# Fire Protection Report

## Final Plat

May 1, 2024

SE 1/4 SECTION 33  
FINAL PLAT

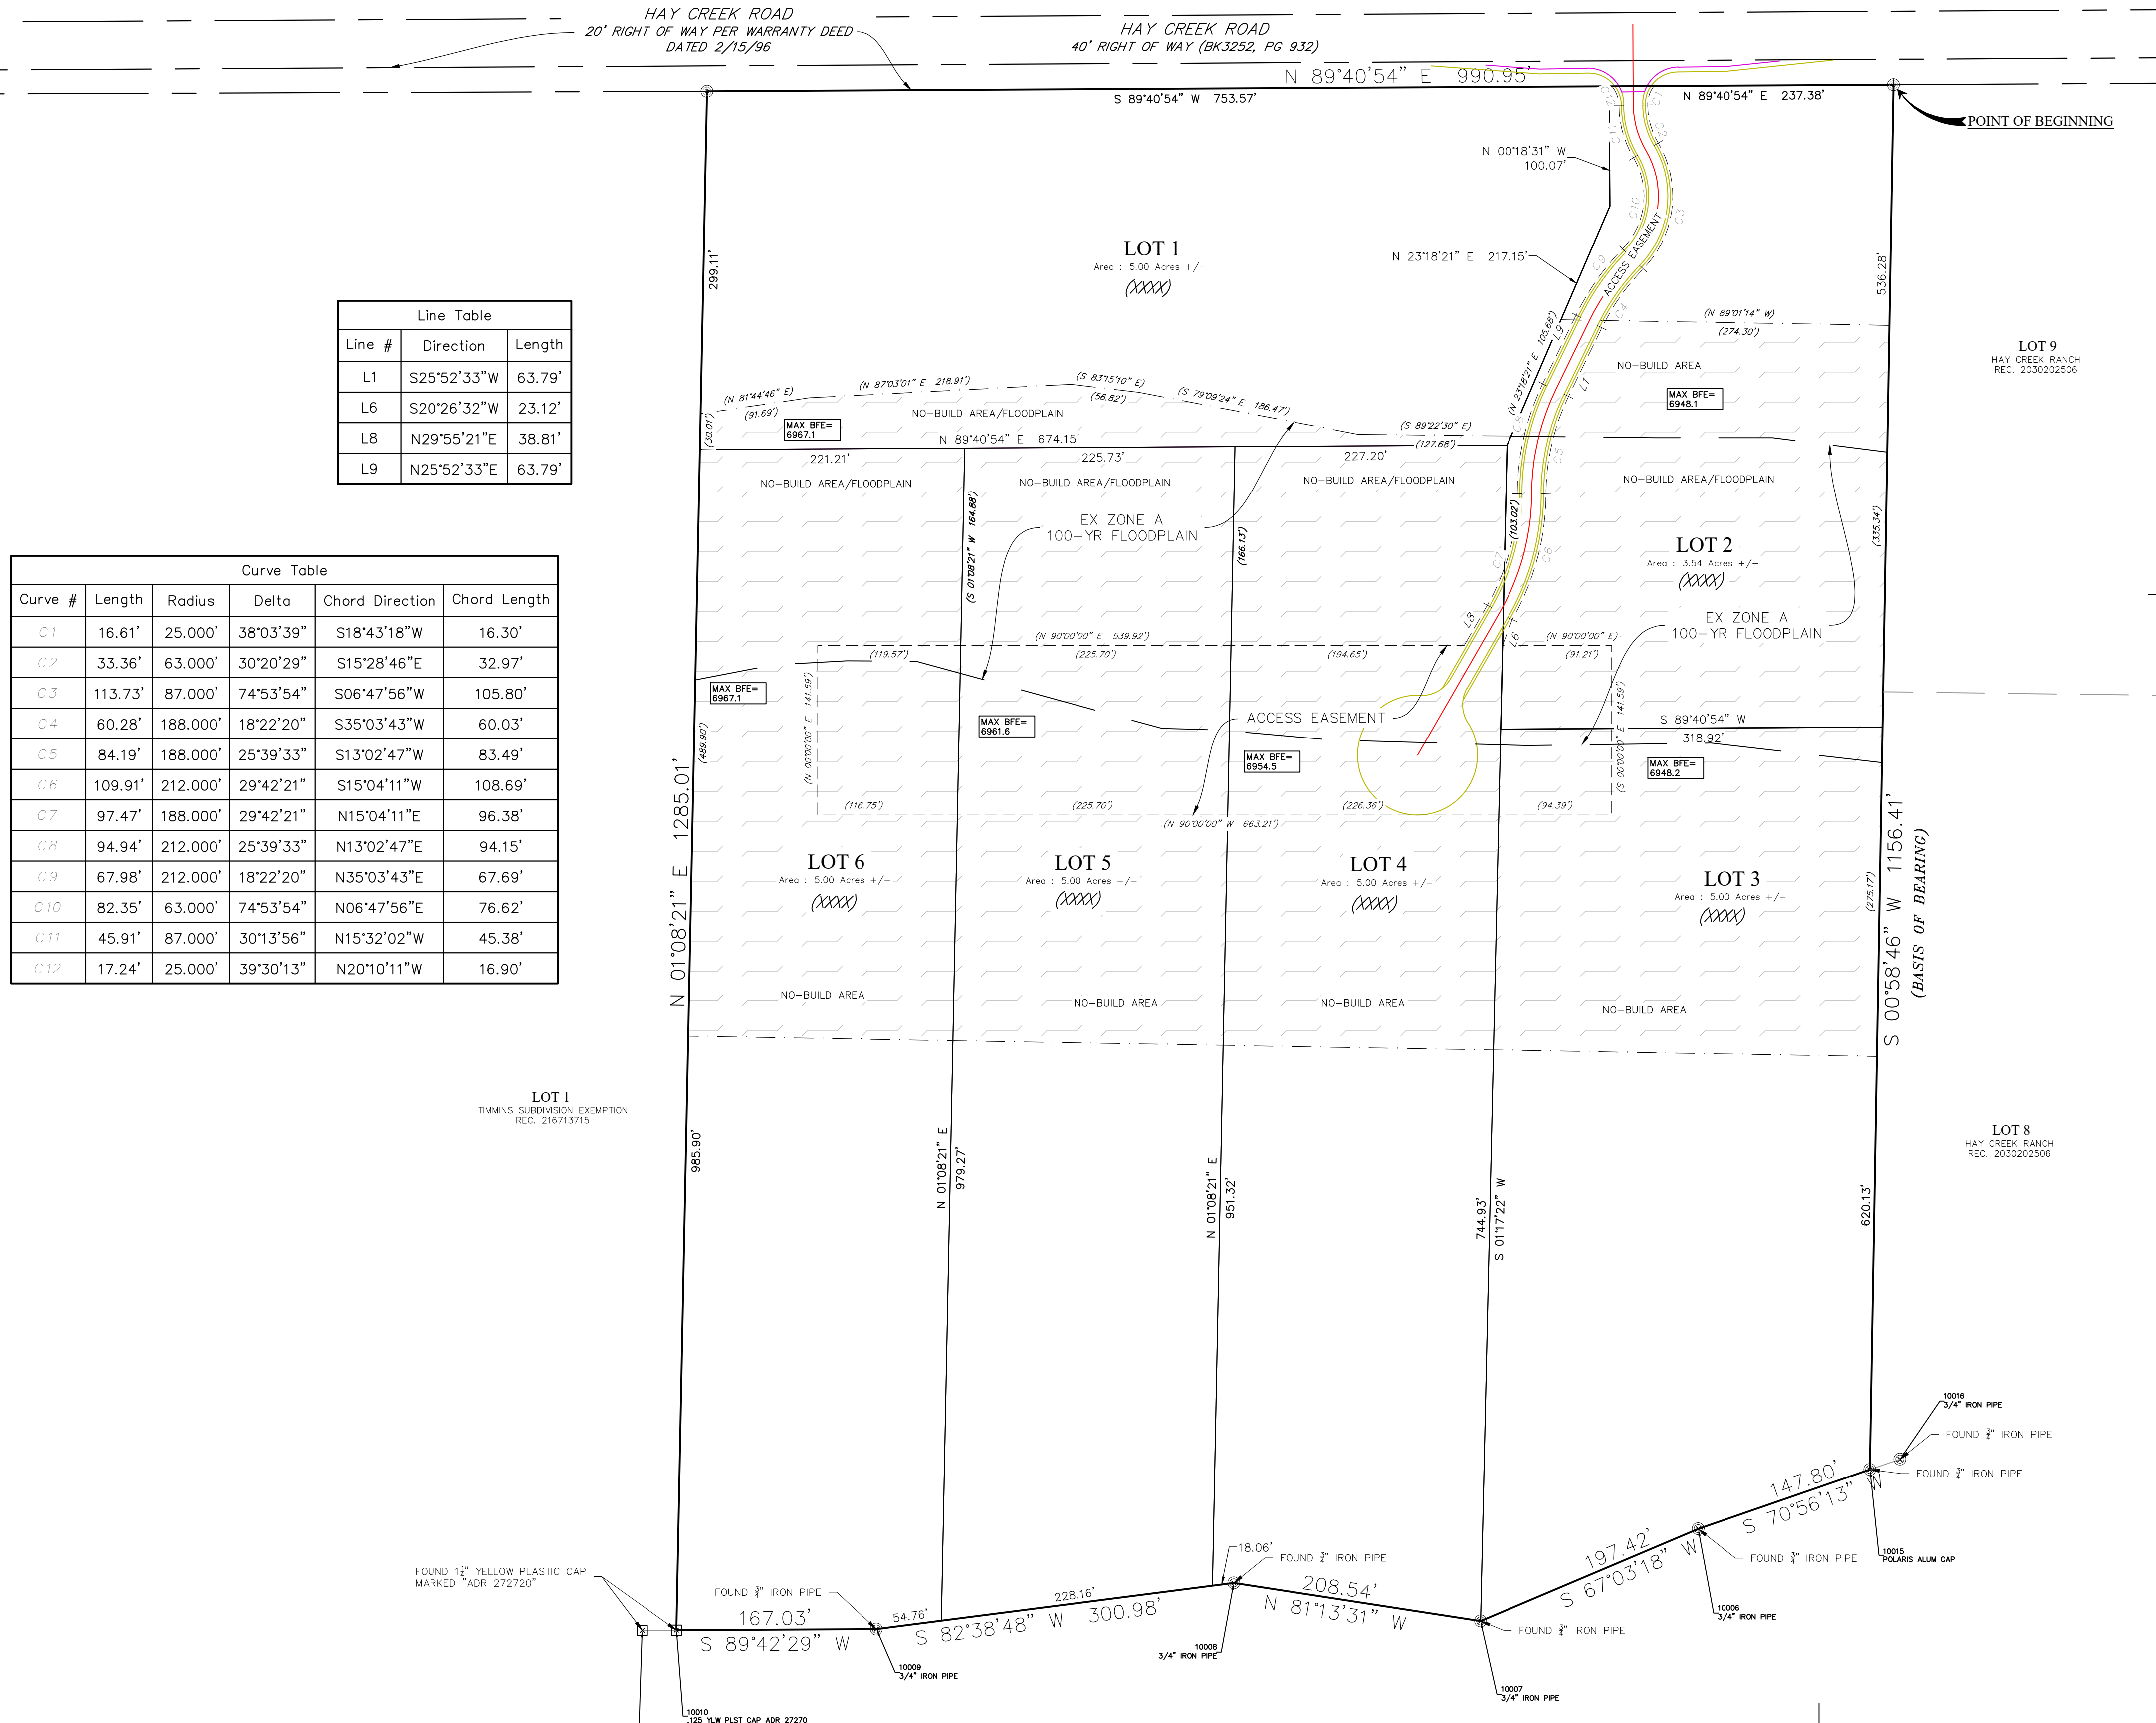
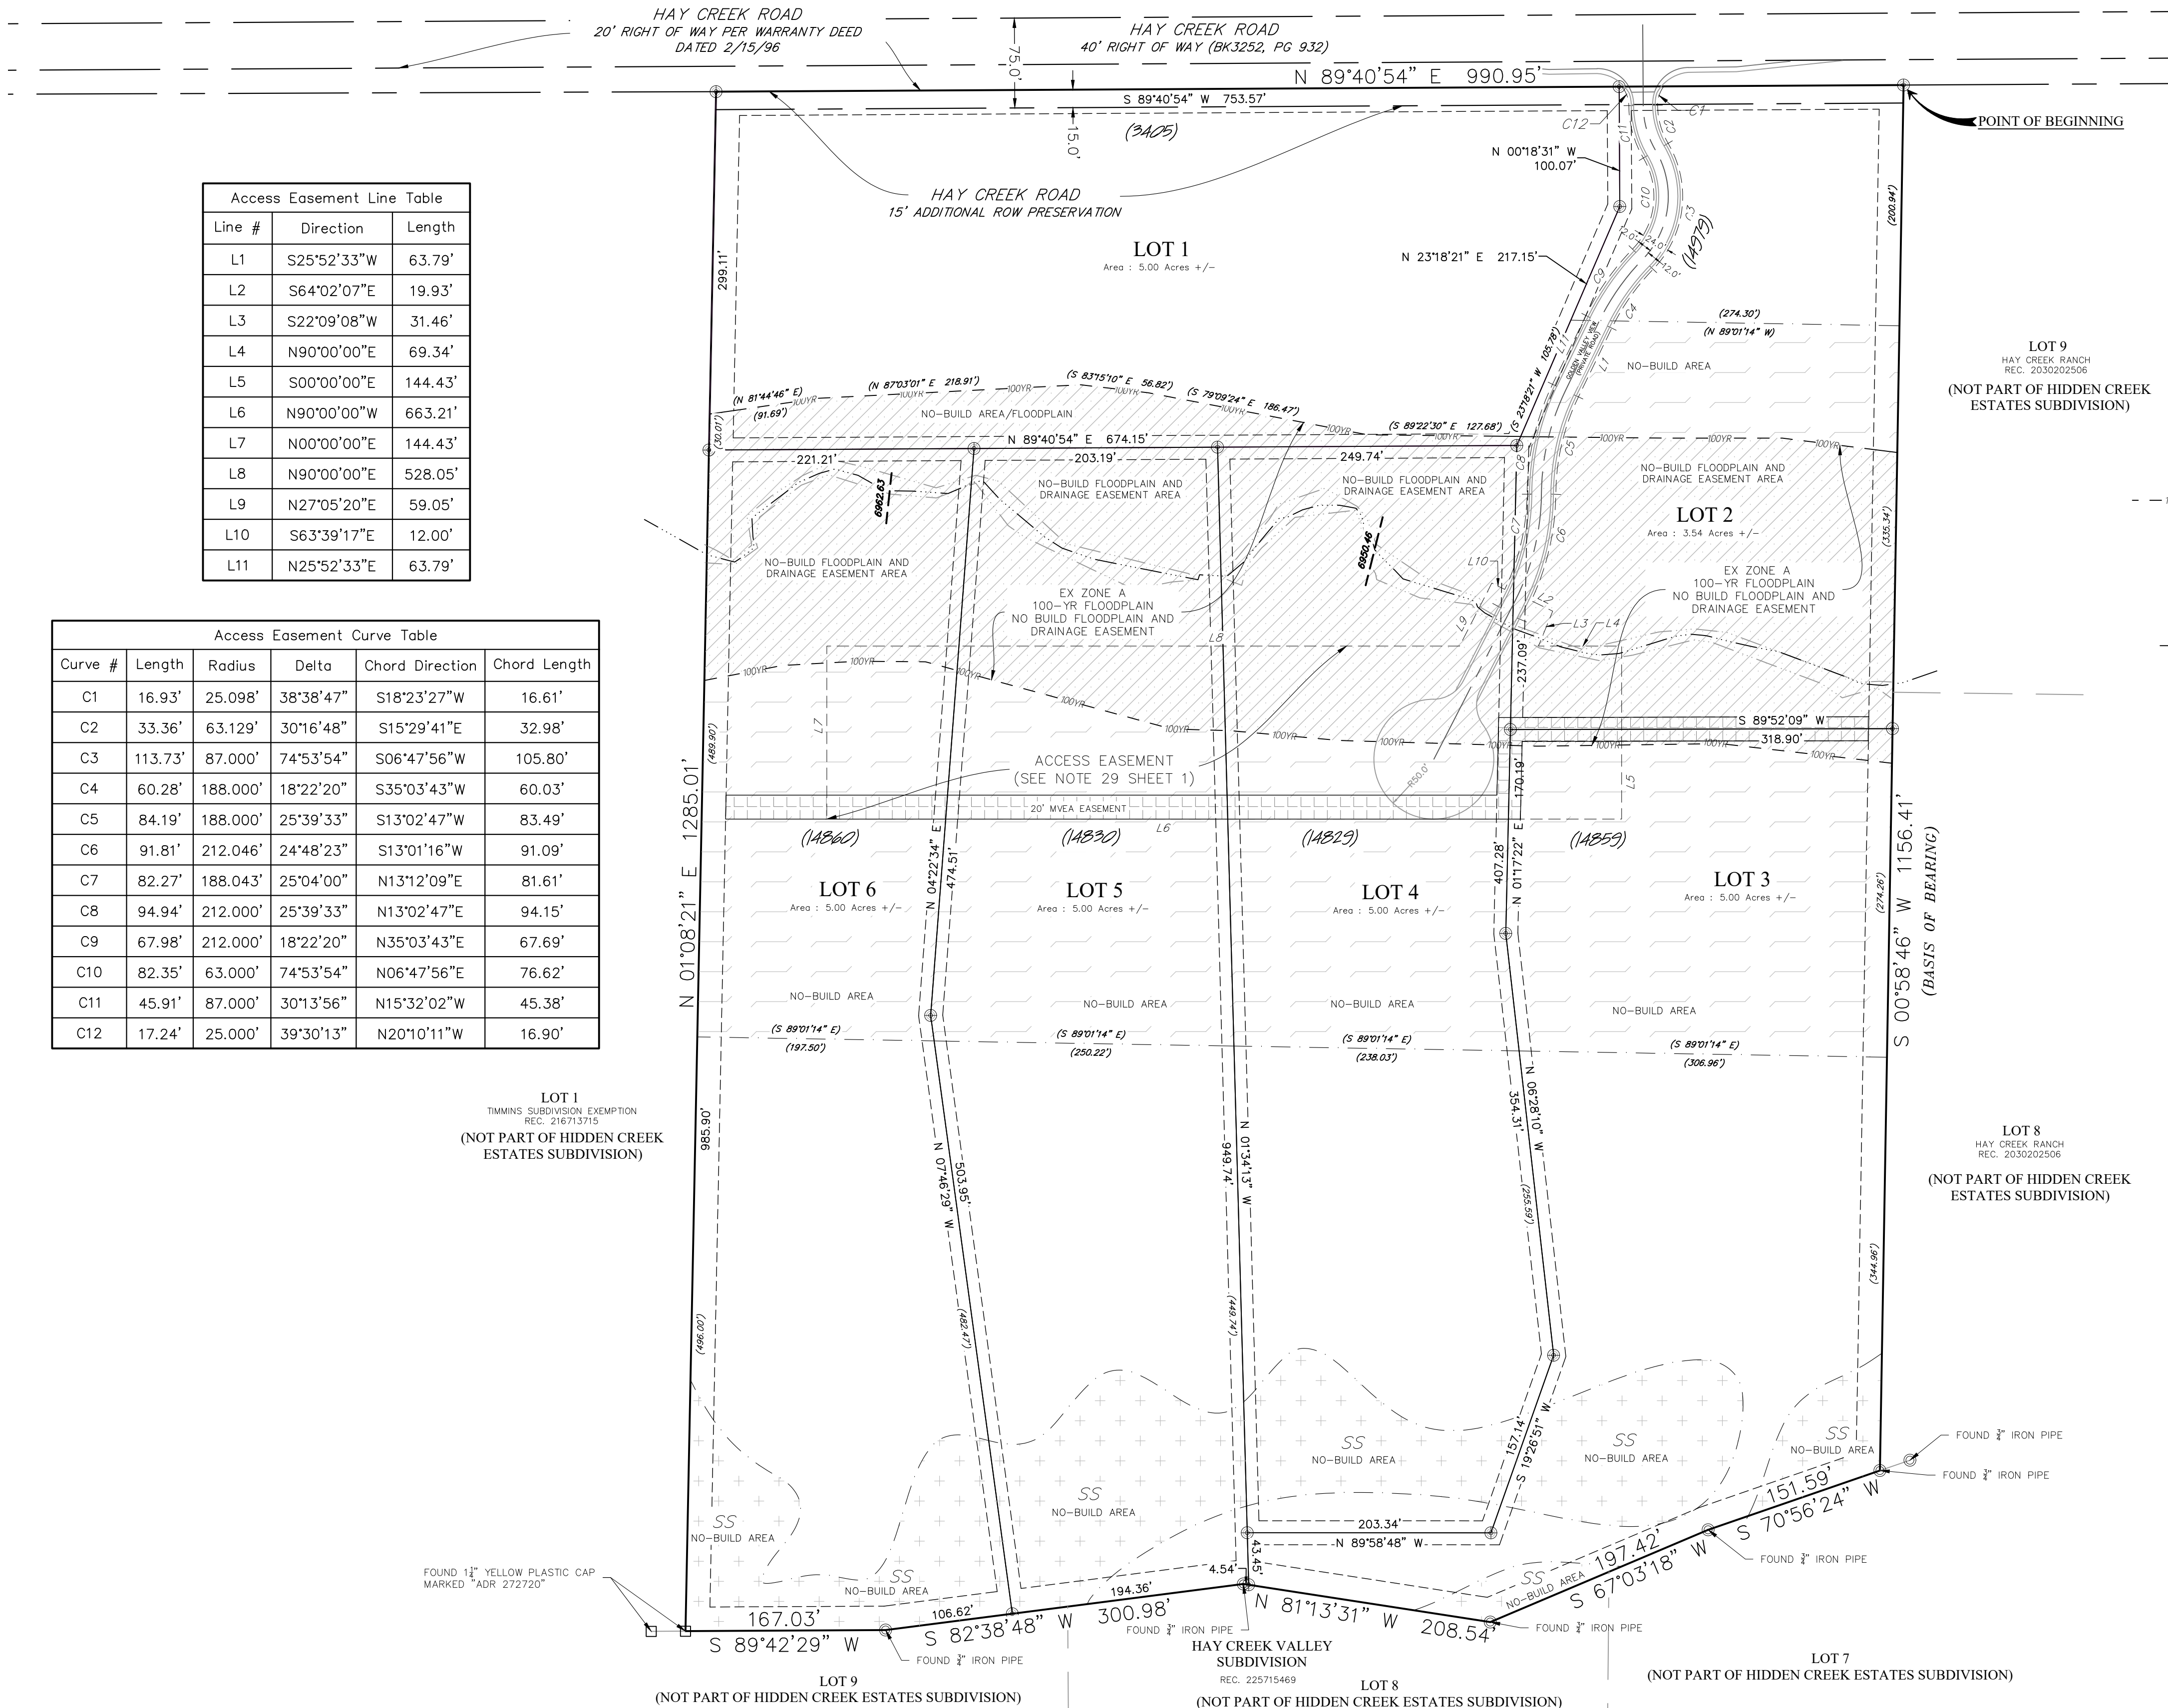
The document provided for a shared cistern agreement and exhibit shows 3 properties, 3405 Hay Creek LLC, Matthew Dunston at 4420 Green Mountain, and Randall O'Leary at Haycreek Ranch Subdivision. The fire department has accepted a plan to share a cistern with only O'Leary (see fire comment).

Provide the written agreement requested by fire department for access.

Either get the fire department to agree to the shared Dunston cistern or remove that property.

The O'Leary cistern has been platted into a tract as part of the Hay Creek Valley subdivision. The owner of the tract is VIVA LAND VENTURES LP. Update ownership.

**RESPONSE: PER MEETING WITH EPC AND PROPERTY OWNER ON 7/8/25 THIS COMMENT NEED NOT BE ADDRESSED PROVIDED THE FIRE DEPARTMENT PROVIDE LETTER REGARDING FILLING HYDRANTS AT NEARBY HYDRANT.**

**RESPONSE: PER MEETING WITH EPC AND PROPERTY OWNER ON 7/8/25 THIS COMMENT NEED NOT BE ADDRESSED**
